From: Paul Cann
Sent: 27 September 2017 15:39
To: Planning.Responses
Subject: RE: Planning Consultation on EG/71/17/DOC

APPLICATION NO: EG/71/17/DOC

Registered: 30-AUG-17
Site Address: Woodfield Farm Wandleys Lane Fontwell Eastergate PO20 3SE

Description of Works: Application for approval of details reserved by condition imposed under planning permission EG/53/16/PL relating to condition No. 3 - Surface water drainage scheme

Client
Clive Hughes
Drawing Title
Surface Water Drainage

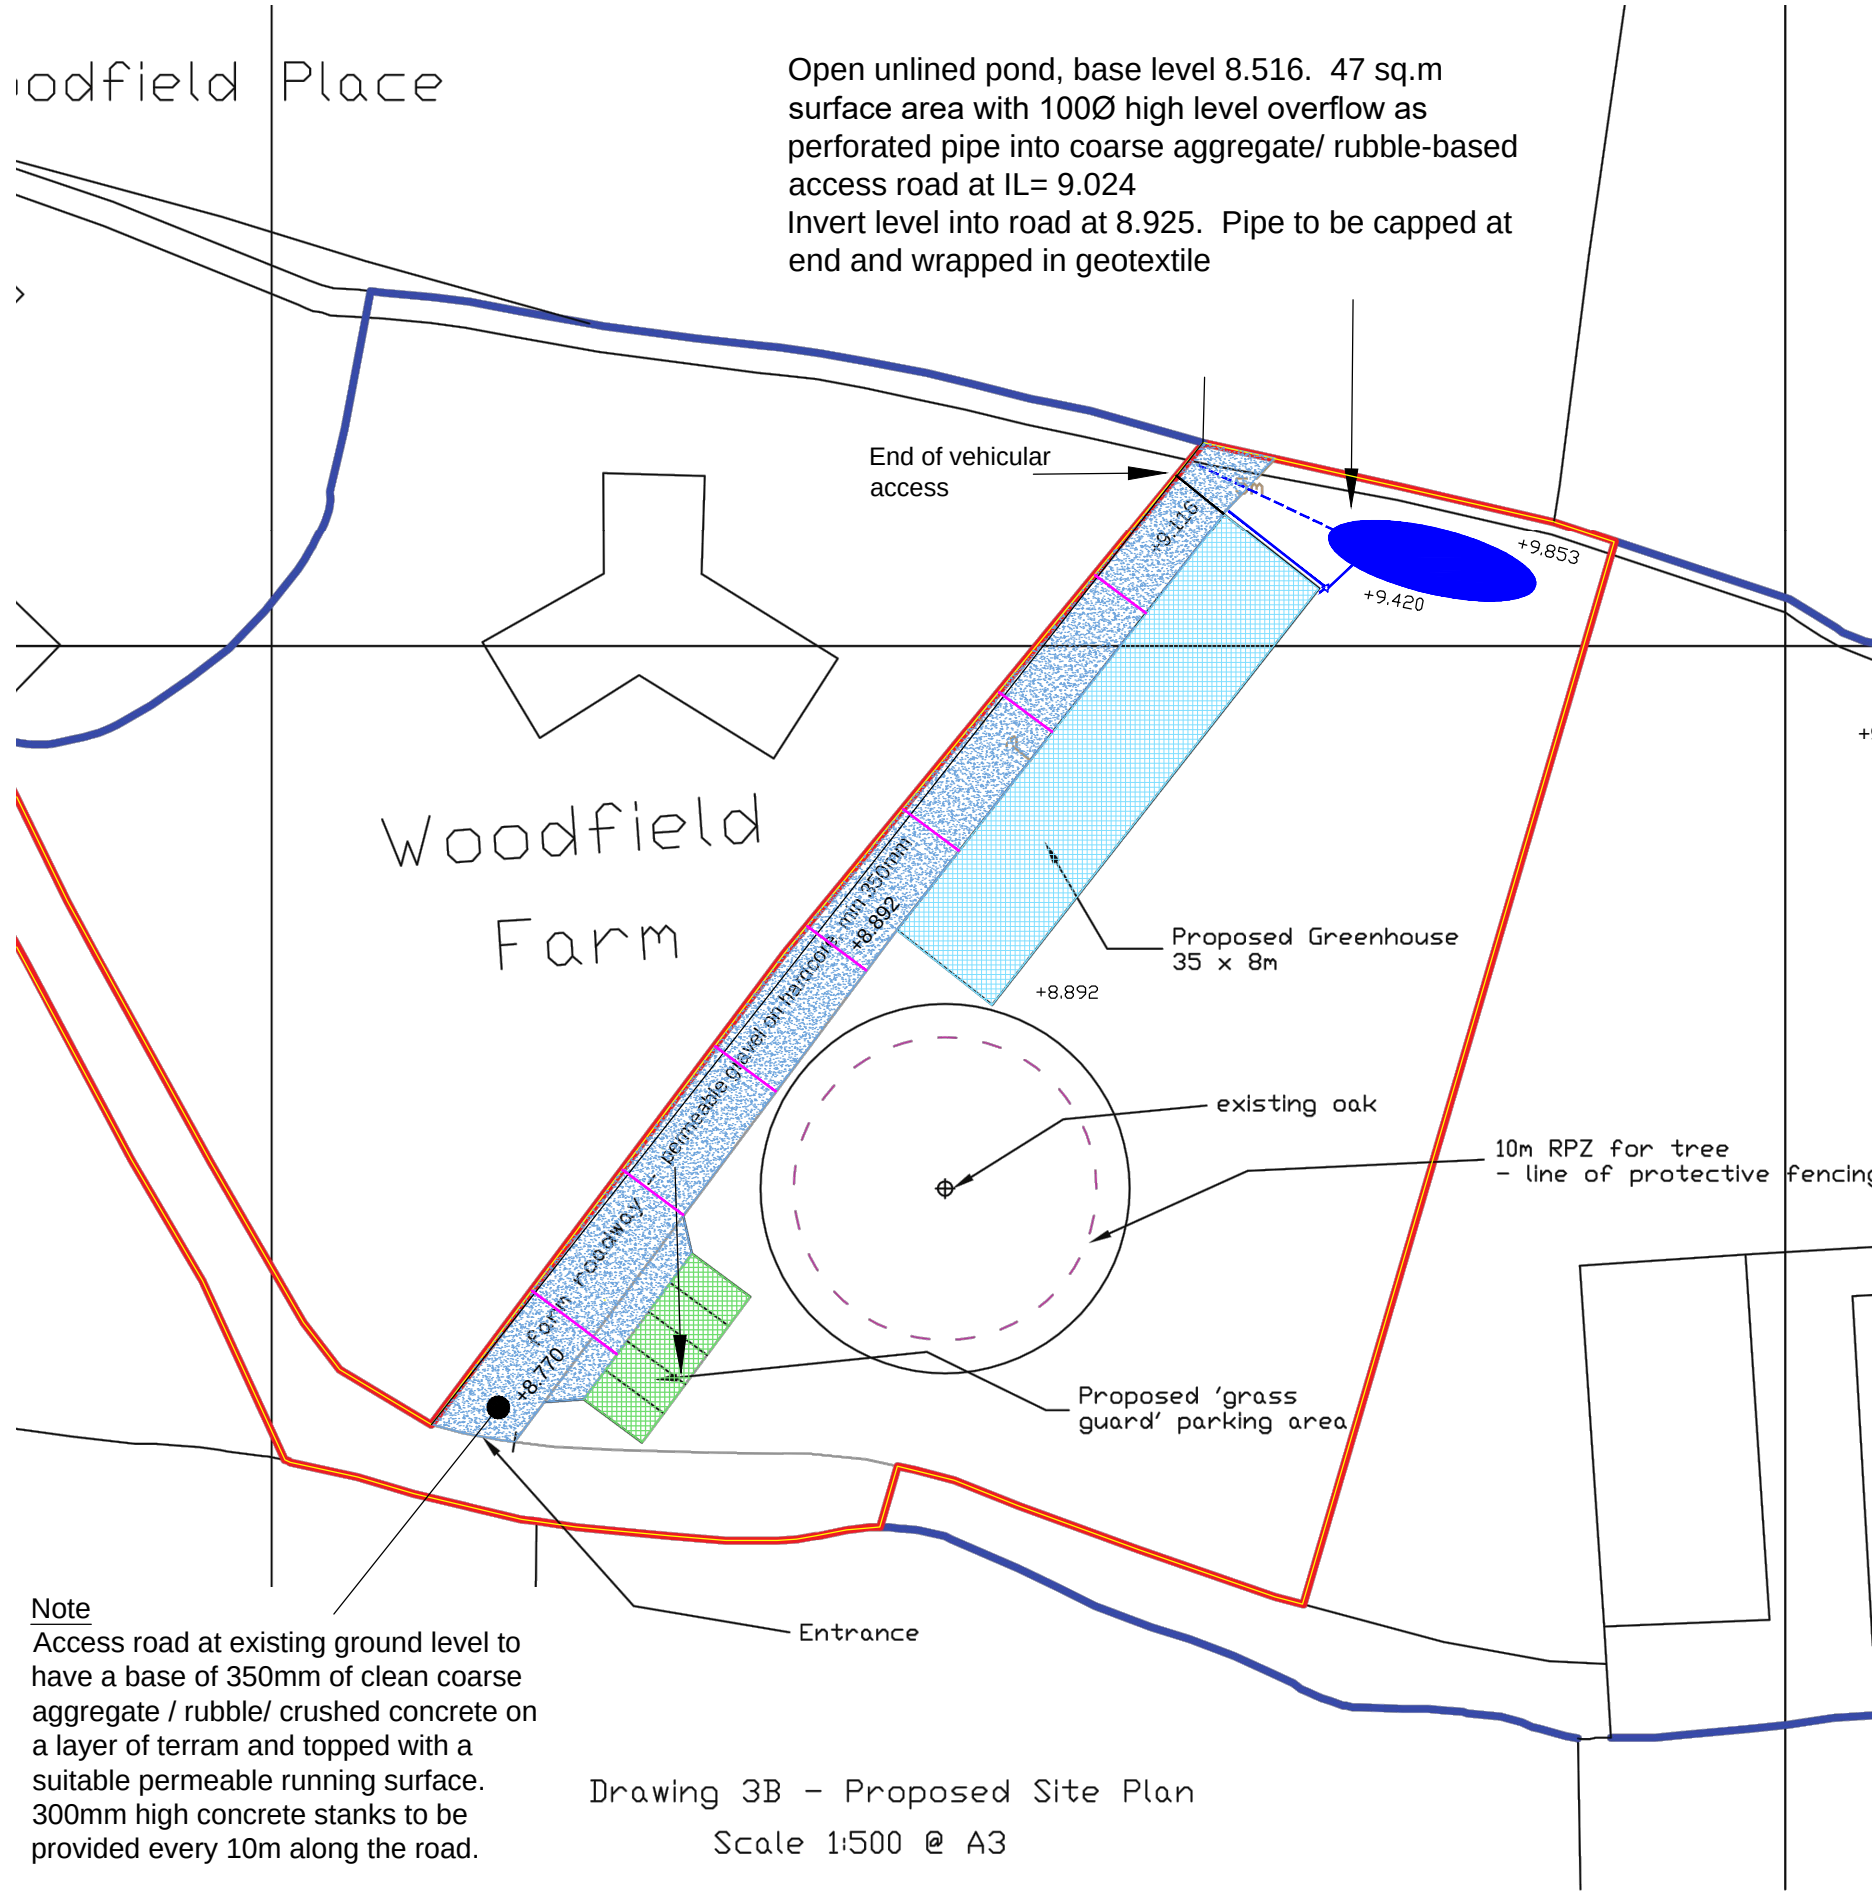
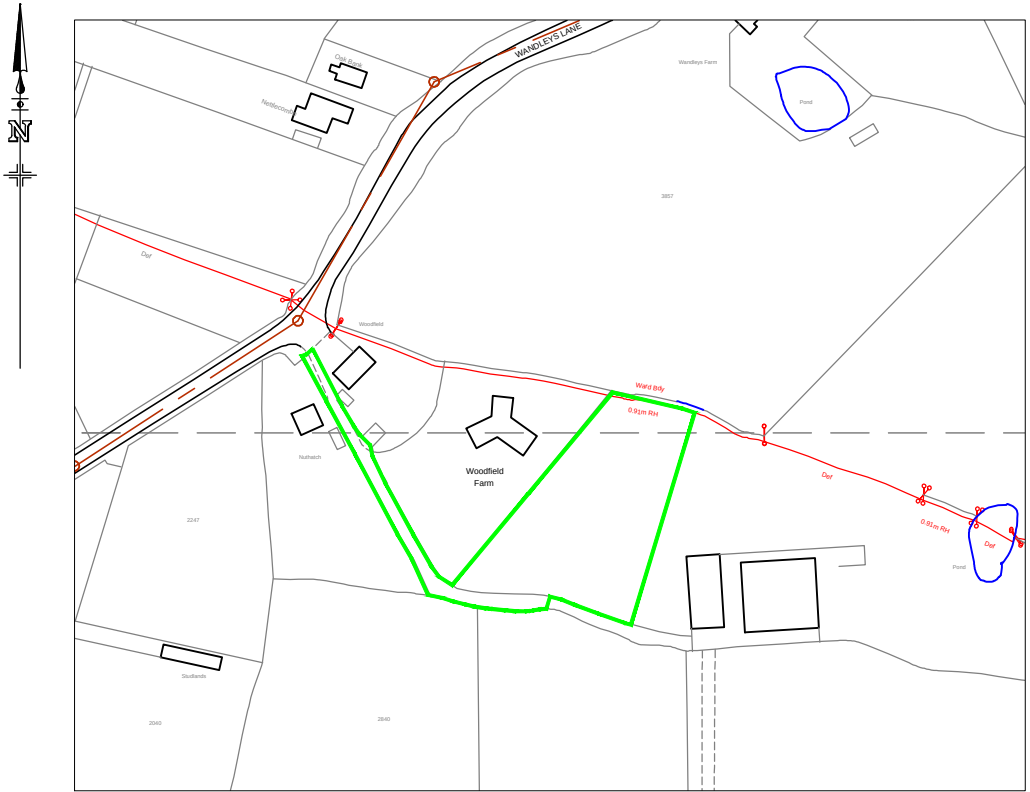
1. No winter groundwater data has been provided but a high water table is expected. A May 2017 reading of 1.16m below ground level is noted. The pond is shown to have a base level approx. 1.06m below ground level (9.420 (from calcs) -8.361) and therefore capacity in the pond is likely to be compromised by groundwater, especially in the winter. The plan indicated an adjacent ground level of 9.853 – further clarification is required in respect to ground levels in the proximity. The pond design will need to be adjusted to suit and will be subject to further discussion/agreement.

2. Percolation tests have not been carried out in the winter. In this instance, a high factor of safety should be applied to the rates and this replicated within the hydraulic calculations.

3. Concrete bag headwalls to be provided on pond inlet/outlet.
4. Specify method/detail of connection to the existing culvert. Connection level should be higher at 9.075m. ie. soffit to soffit.

5. Specify pipe inlet level into pond.
6. Roadway – noted to be a permeable gravel surface. Provide construction detail/storage calculations. Run off from the 1 in 100 year storm event + climate change allowance will need to be stored on site. Finished surface levels for the road need to be specified.
